Mr David Glasgow
Principal Planning Officer
Key Sites Assessments
Department of Planning, Industry and Environment
GPO Box 39
Sydney NSW 2001

**Harbourside Shopping Centre Redevelopment (SSD-7874)
Response to Submissions and Further Amended Concept Proposal**

Thank you for your correspondence via the Major Projects Portal on 16 October 2020, requesting Transport for NSW (TfNSW) to review and comment on the above.

Image 114 Basement access, and Darling Drive drop off locations

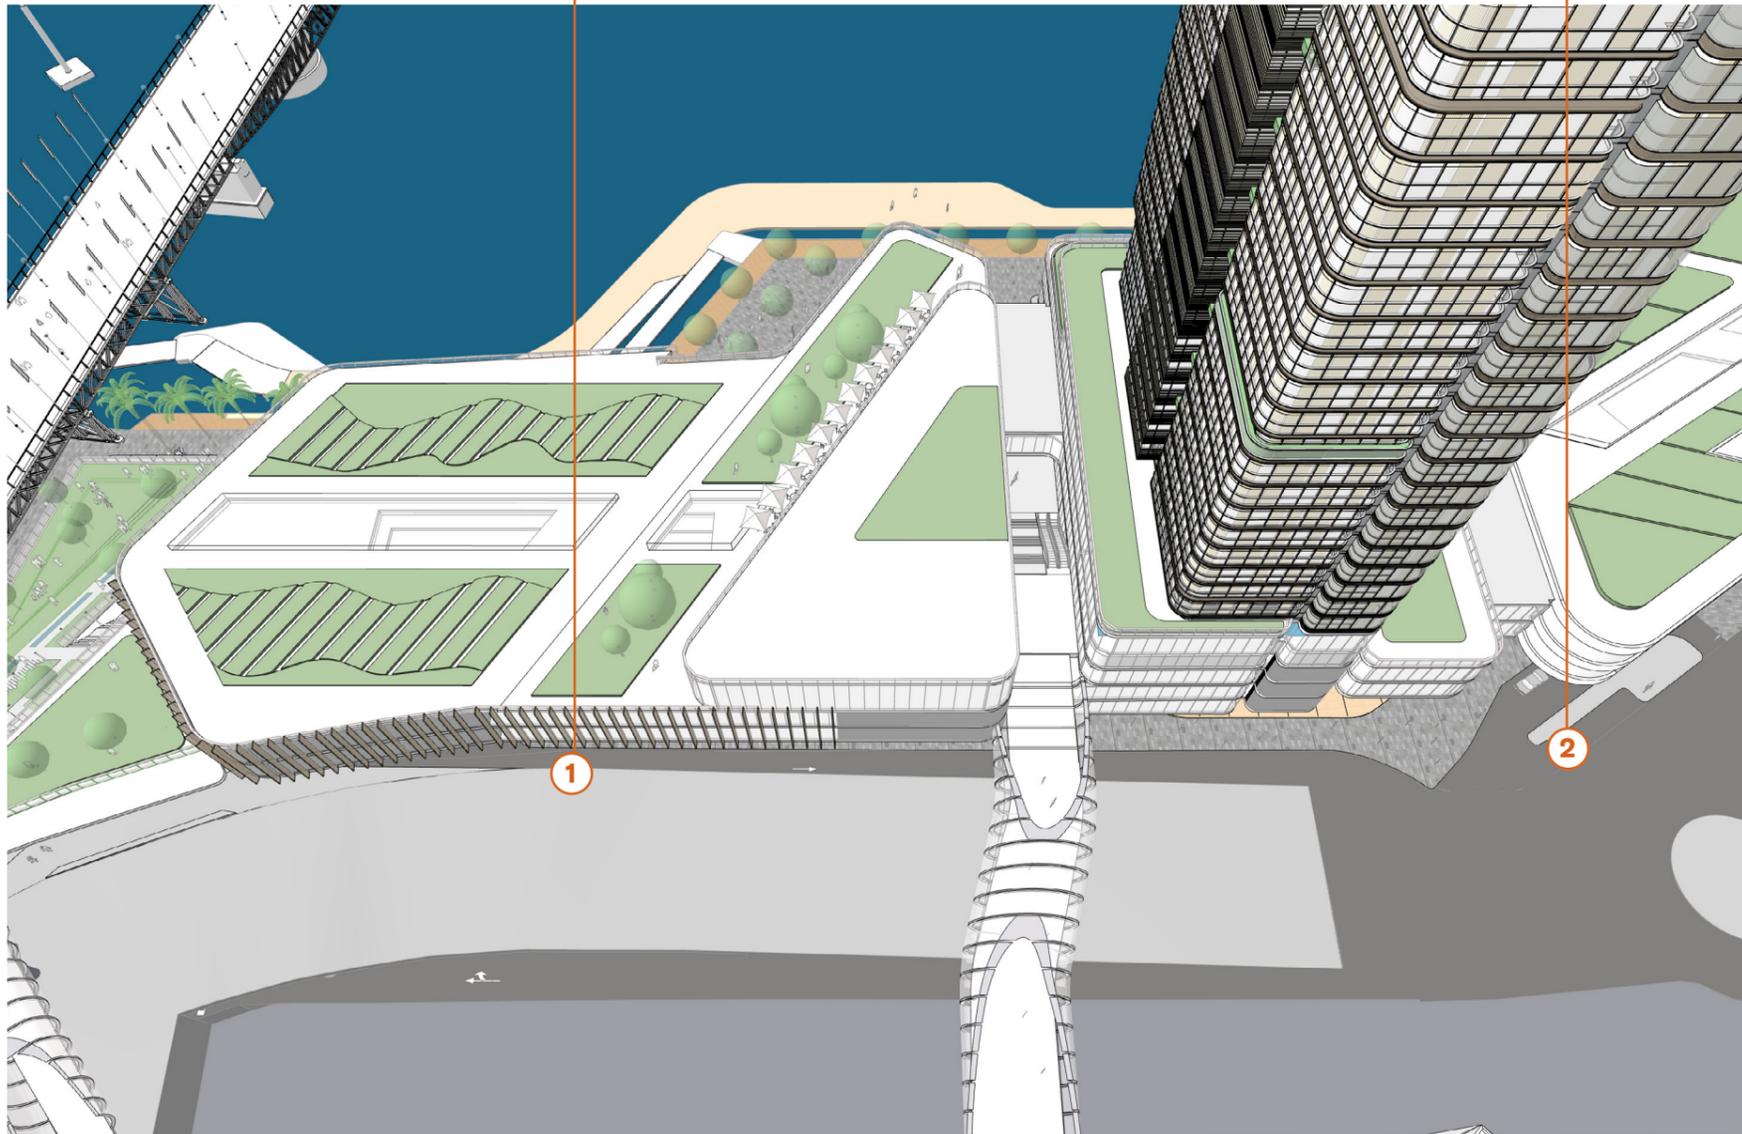
It is advised that the vehicles queuing to access this drop off zone, the car park and loading and servicing would have potential to cause delays to vehicles travelling on Darling Drive.

- Queuing analysis and/ or traffic modelling to demonstrate the drop off area has adequate capacity and propose mitigation measures to ensure queuing on Darling Drive does not occur, to the satisfaction of TfNSW; and
- Prepare draft management plans for Drop-off and Pick-up Zone and Carpark and Loading Dock to manage vehicles accessing the site.
